Recommendation Report for Planning Permission for Works or Extension to a Dwelling

REF NO: FP/92/19/HH

LOCATION: 17 Drake Park
Felpham
PO22 7QG

PROPOSAL: Two storey side and single storey rear extension

Project	Two storey extension at 17 Drake Park, Bognor Regis		Date	11.03.19	Drawn by	AA
	Drawing		Scales	1:100 @ A3	Status	Planning
		Job No	1702	Dwg No	A-23	Revision
						B

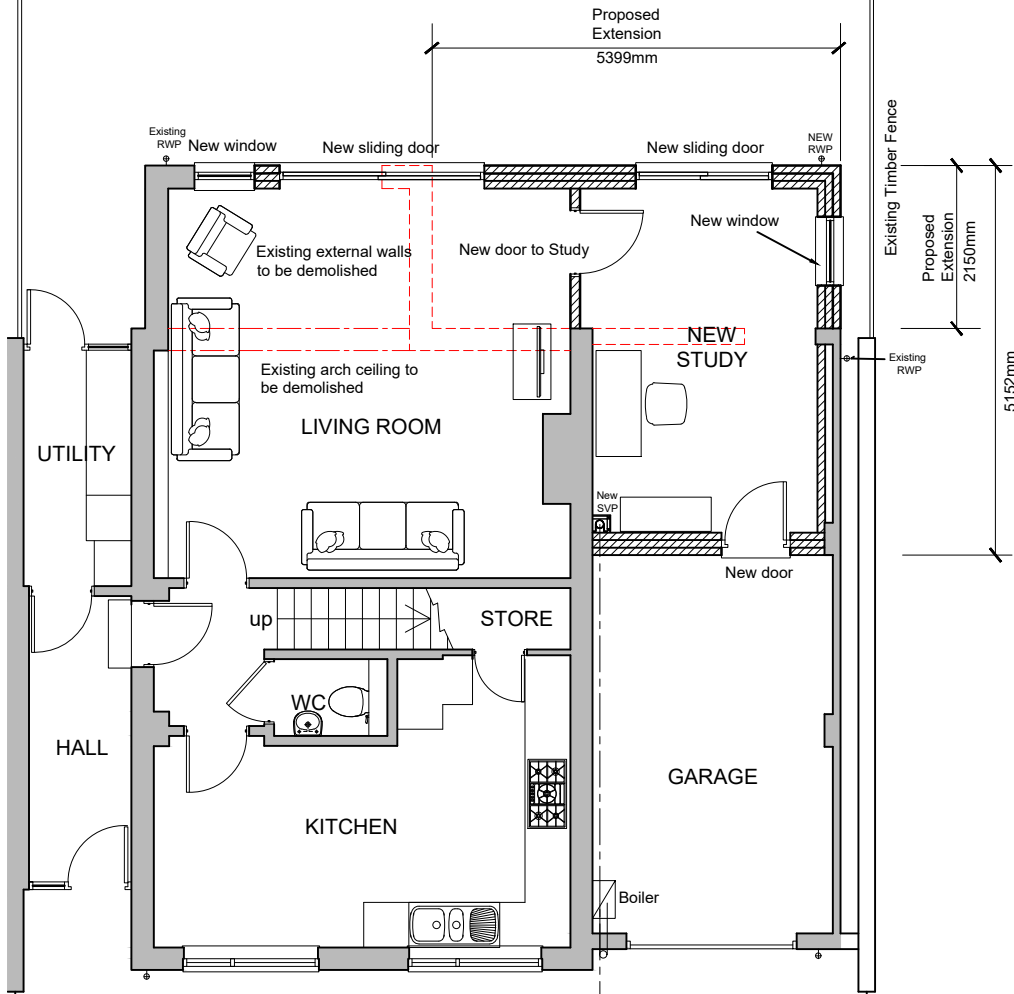
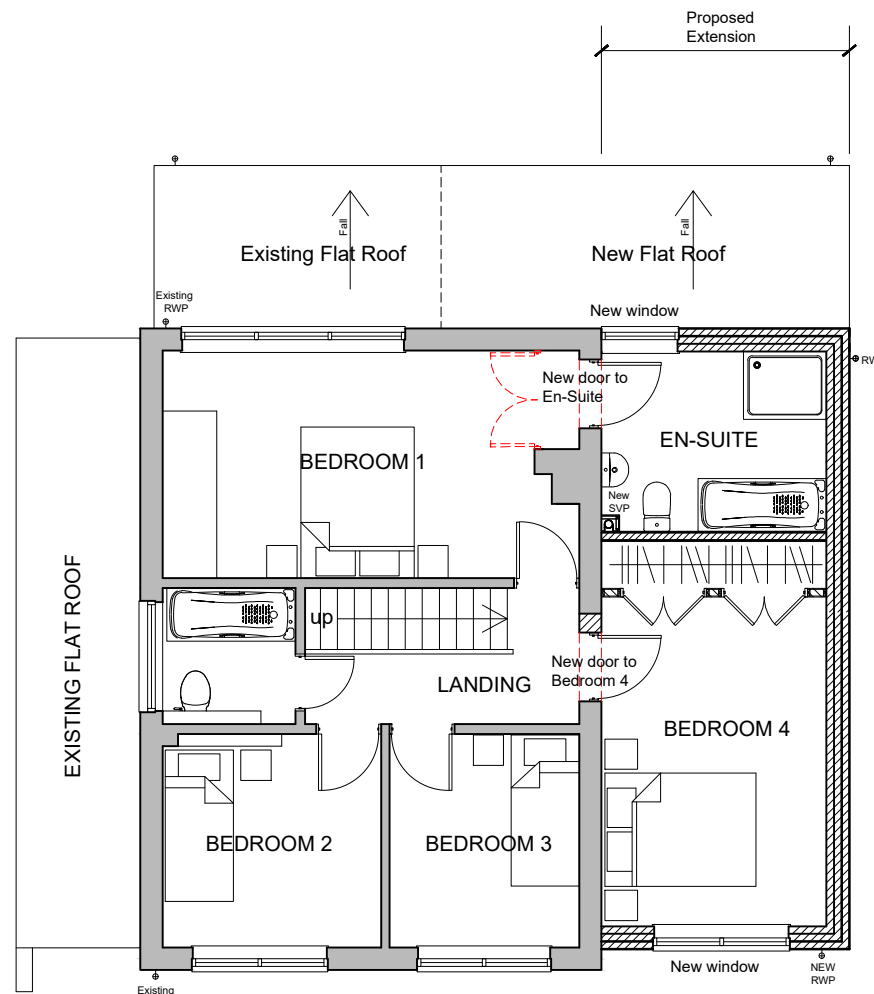
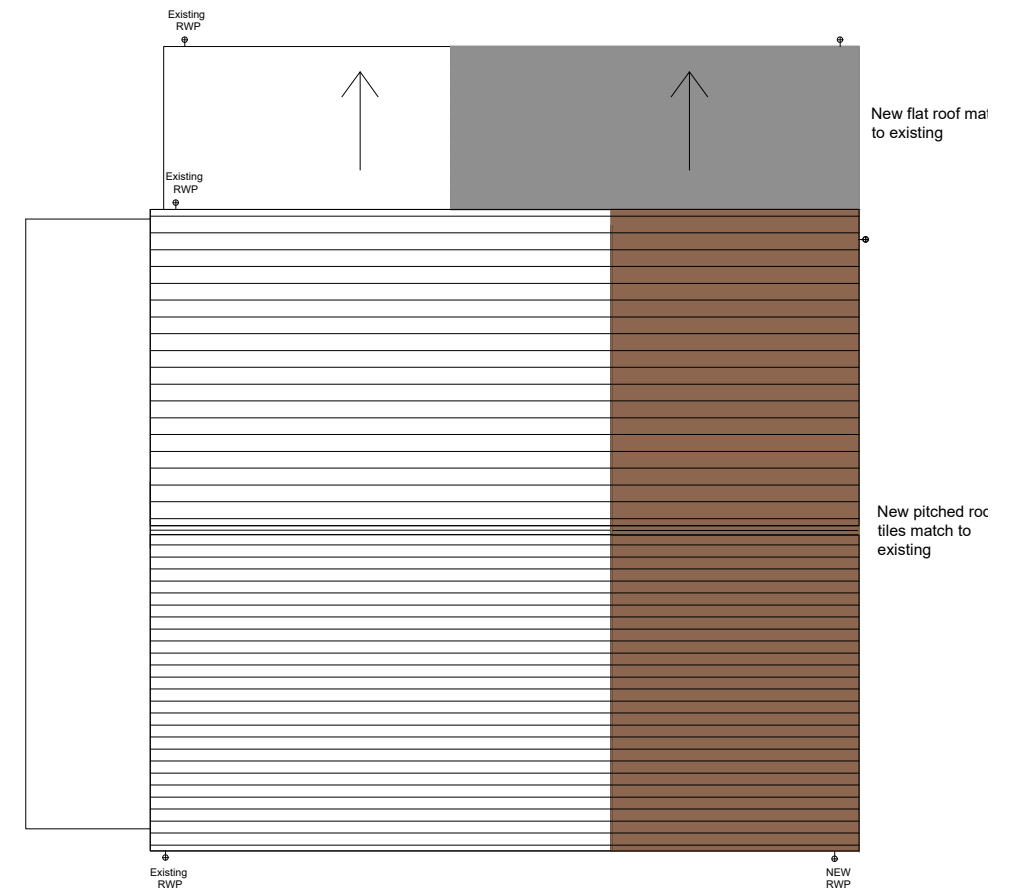
The first floor side extension will run along the western elevation. The development will then decrease to single storey level and run along the rear to meet with an existing single storey addition.

The single storey extension will have a modest depth of 2.15m and will meet with the existing addition running the full width of the rear elevation. It will have a flat roof to a height of 2.85m. There will be a window to the west however again due to the development at single storey height and boundary treatment in place it is not deemed to provide adverse overlooking. As a result of its modest size it is also not considered to appear overbearing or overshadowing upon neighbouring amenity.

Project	Two storey extension at 17 Drake Park, Bognor Regis	Date	11.03.19	Drawn by	AA
Drawing	Proposed Elevations	Scales	1:100 @ A3	Status	Planning
		Job No	1902	Dwg No	A-24
				Revision	B

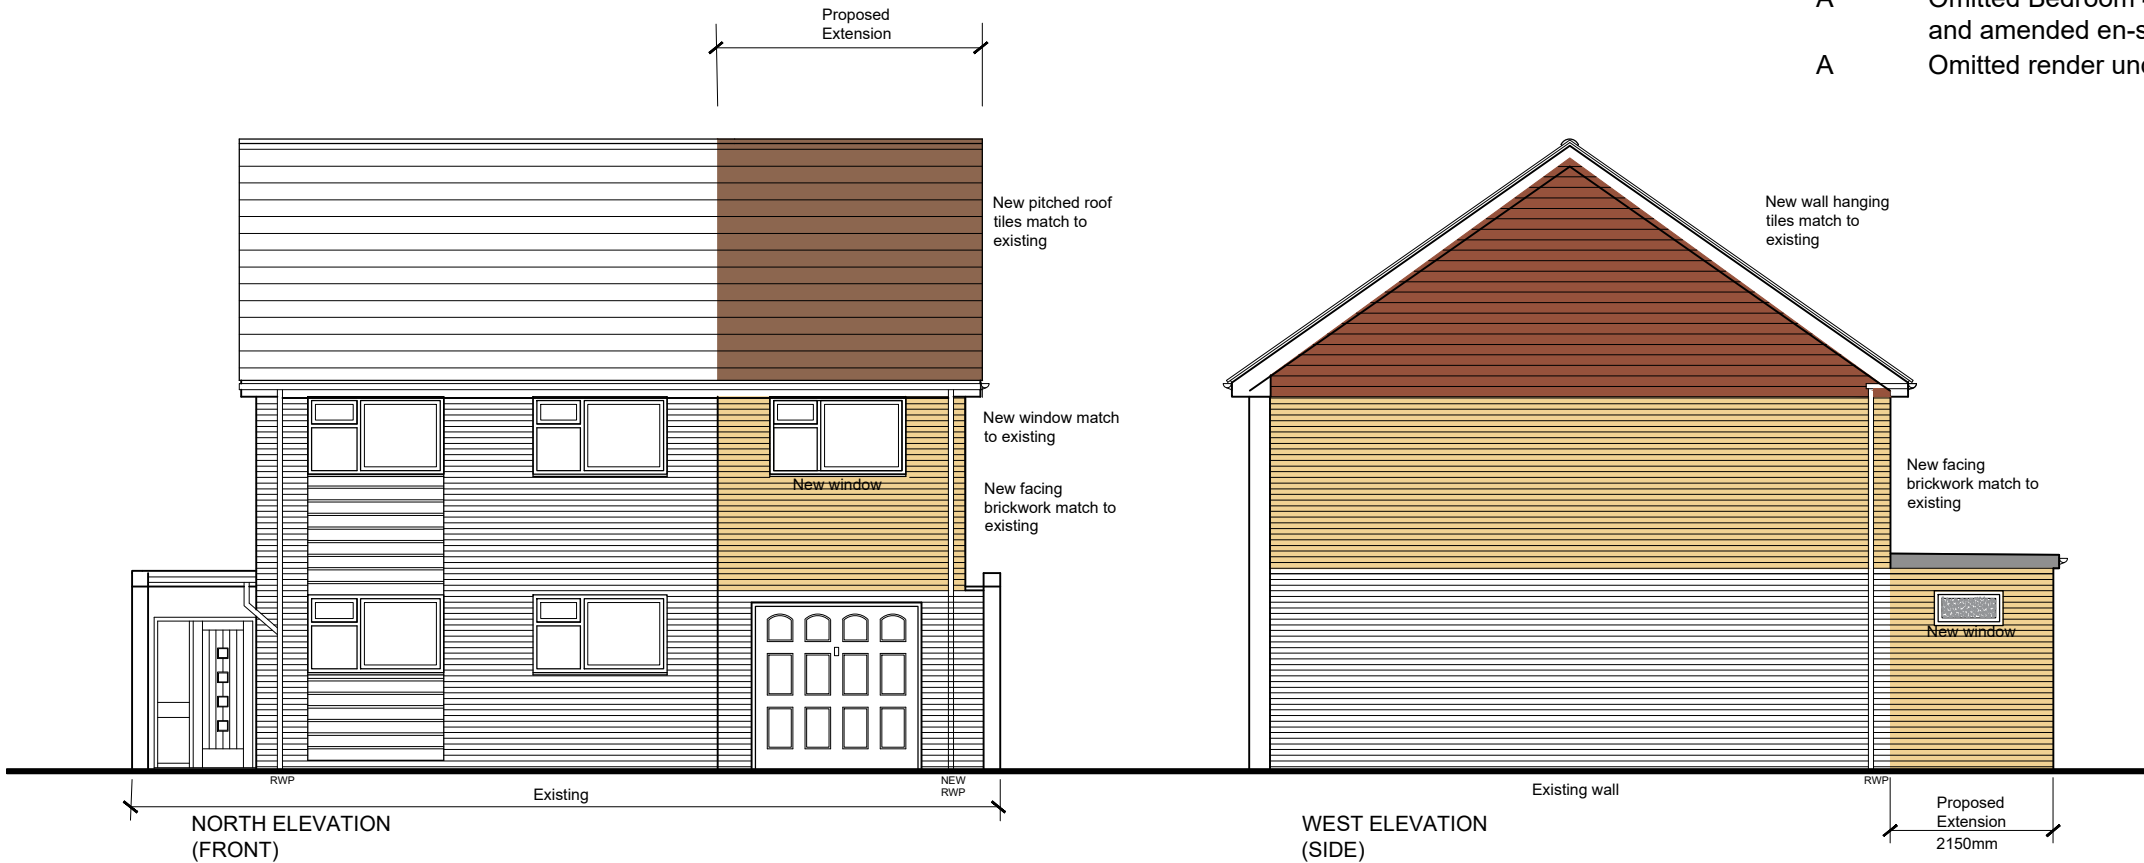
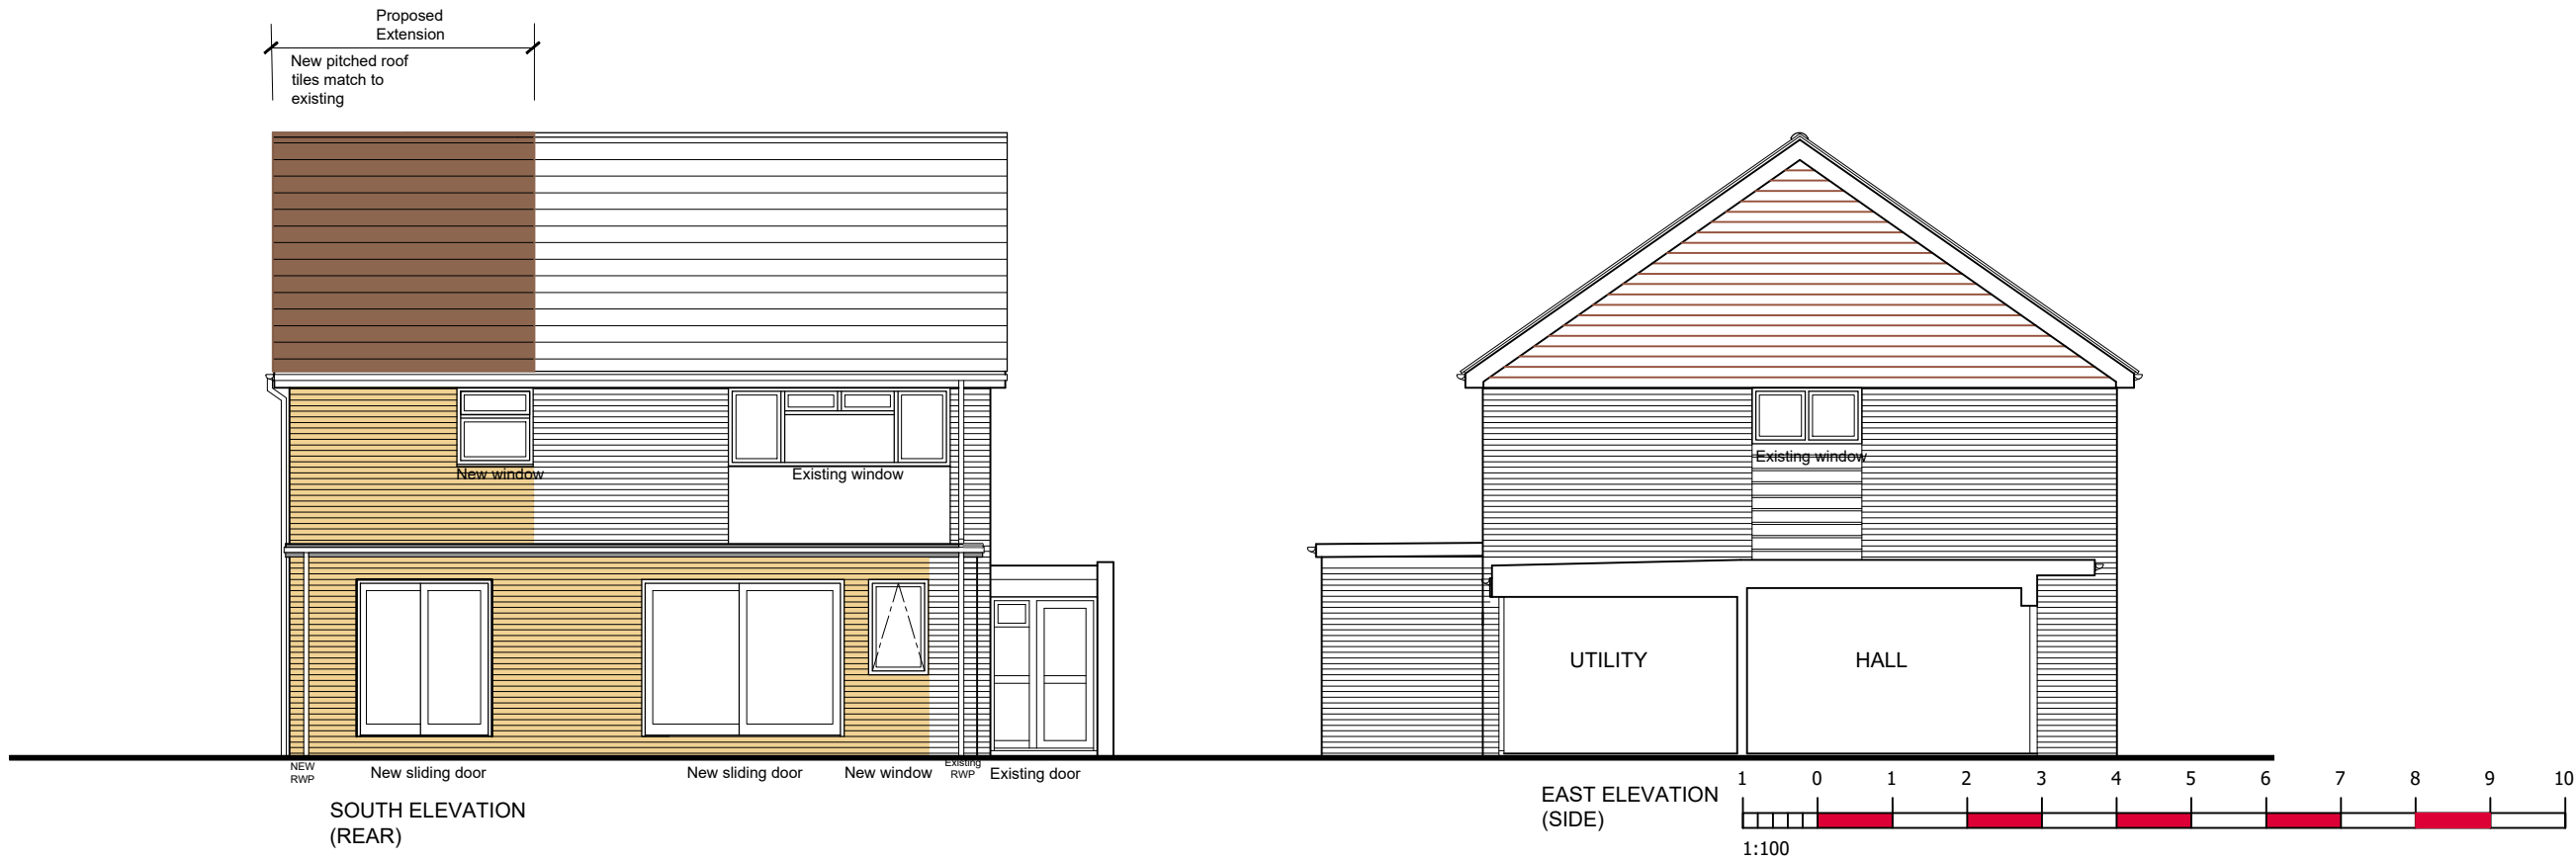
The first floor is not considered to appear adversely overbearing or overshadowing as it does not extend beyond the rear elevation of the host or neighbouring property at No.19. The host dwelling proposes no windows to first floor western elevation. No.19 does have a window situated to the first floor side elevation however as it serves a bathroom and with separation retained any resultant impacts are not considered significant.

There will be 1 additional window to the first floor rear elevation. Whilst it serves a bathroom it will be conditioned to be obscured glazed as the neighbouring conservatory is constructed of glass and due to its siting it could give rise to adverse views and therefore this will ensure there is no unacceptable overlooking.

- 4 The first floor window on the southern elevation of the building shall at all times be glazed with obscured glass and only openable at a high level, at least 1.7m above finished floor level.
